CITY OF ALBUQUERQUE

RE: 1200 Lomas Blvd. NE
Grading & Drainage Plan
Engineer's Stamp Date: 05/10/21
Hydrology File: J15D101

Based upon the information provided in your submittal received 05/10/2021, the Grading & Drainage Plan **is not** approved for Paving Permit. The following comments need to be addressed for approval of the above referenced project:

ON-SITE DRAINAGE PLAN

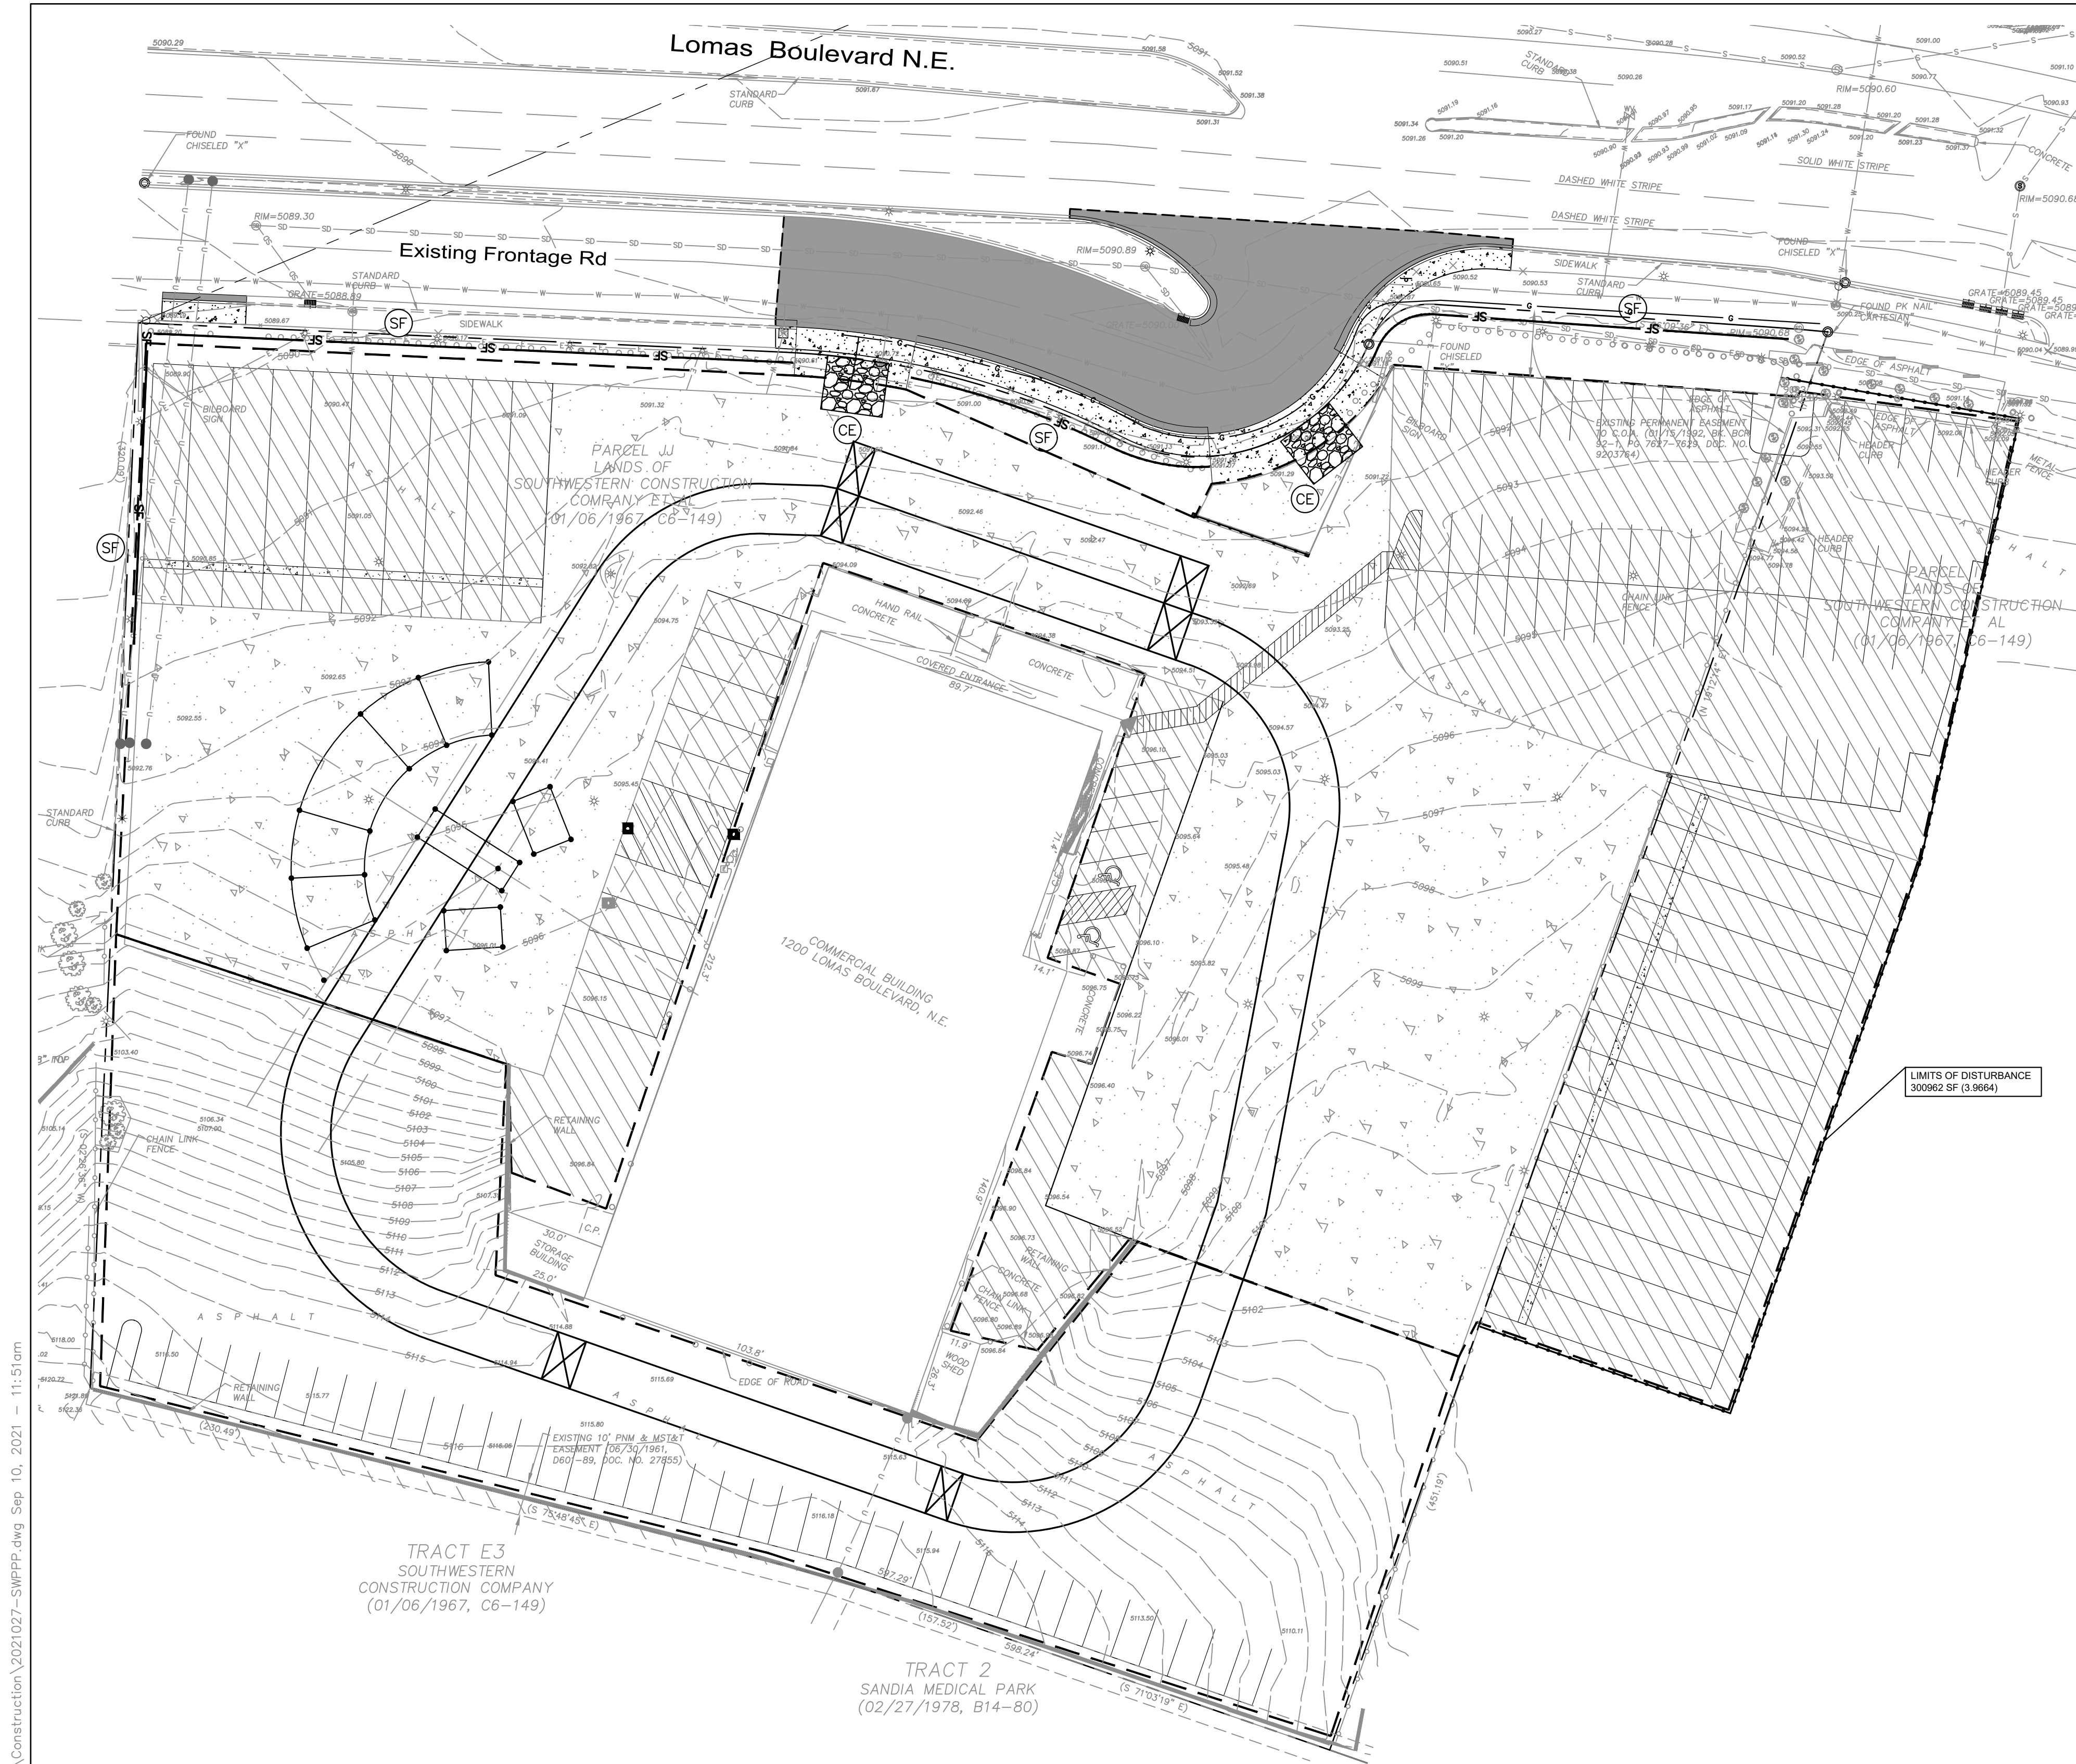
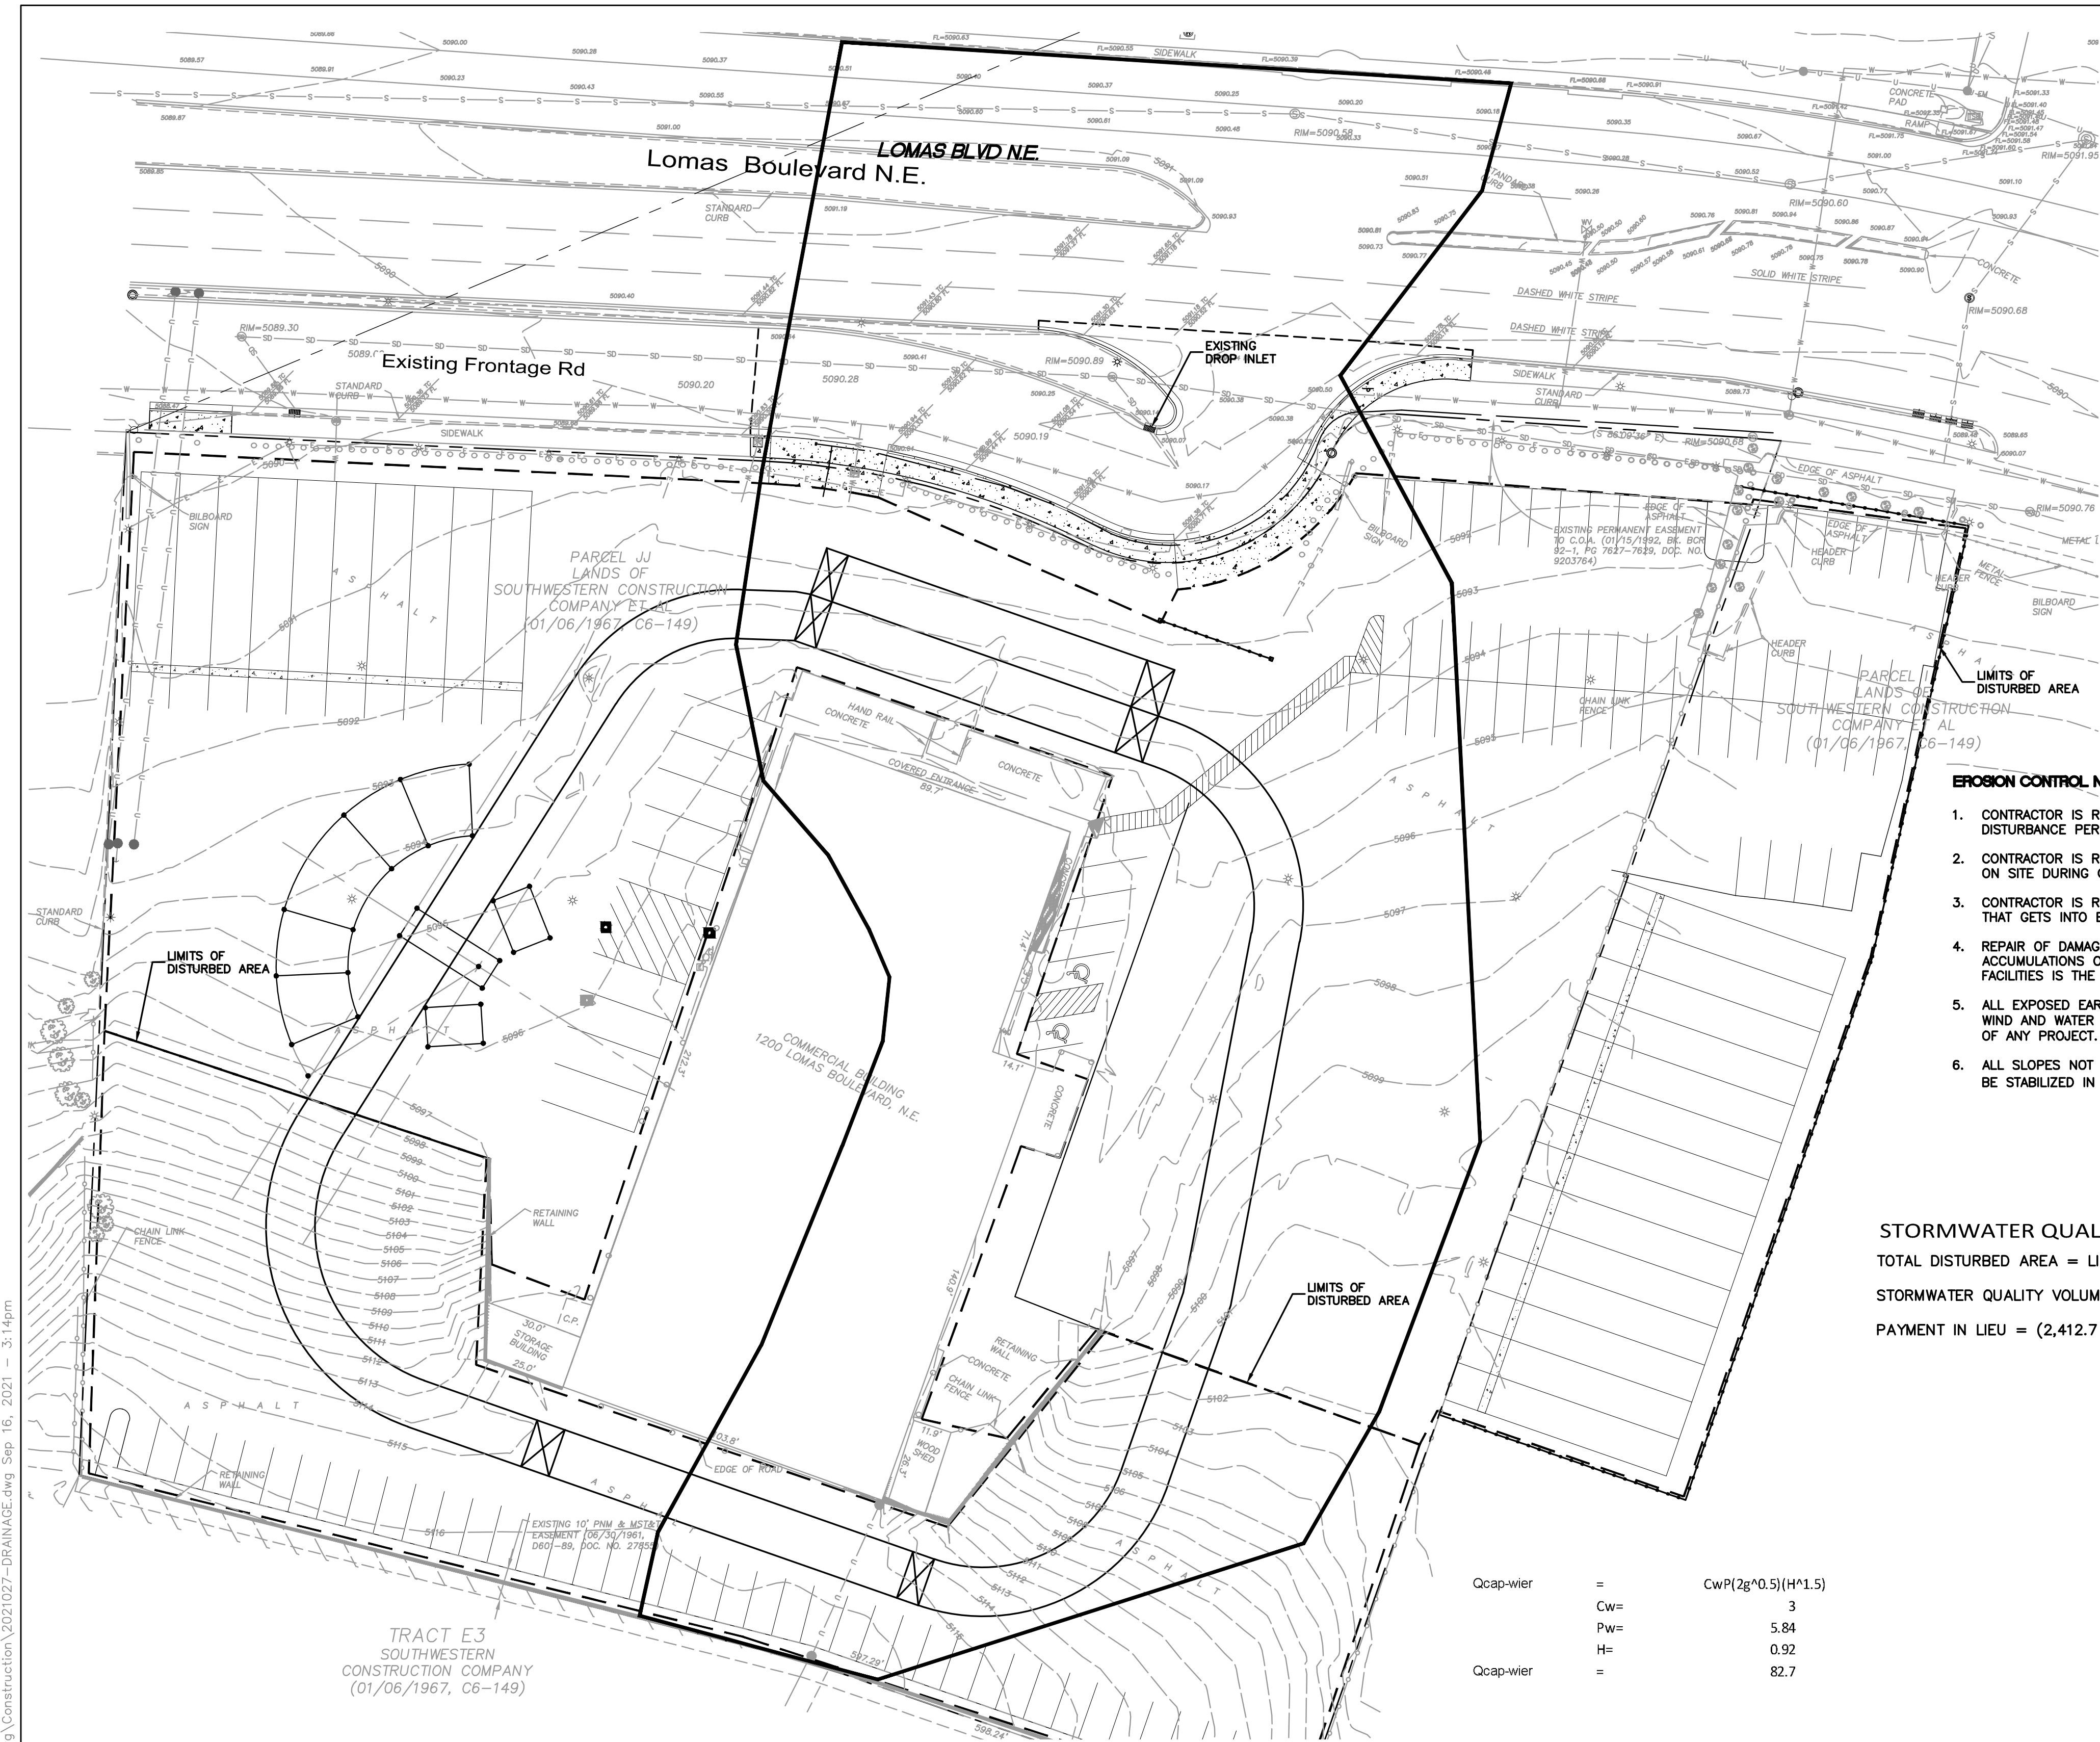
1. Under the Drainage Narrative it states, "...No Water Quality Ponding Requirement is proposed." This is not correct, please provide management onsite for the Stormwater Quality Volume (SWQV) in accordance with the new drainage ordinance, § 14-5-2-6 (H) enacted 10/2/18 (Council Bill C/S O-18-2). Please follow the DPM (signed 06/08/20) Article 6-12 Stormwater Quality and Low-Impact Development for the sizing calculations. Since this project is a redevelopment, calculate the required SWQV by multiply the impervious area by 0.26 inches.
2. If the Owner elects to do a payment-in-lieu for the required SWQ volume, than please add a note which states, "The Owner has elected to pay the Payment in Lieu for the required Stormwater Quality Volume (XX CF *\$8/CF = \$xx.xx.)"
3. Please provide missing survey information within Lomas R.O.W. (please see image below)
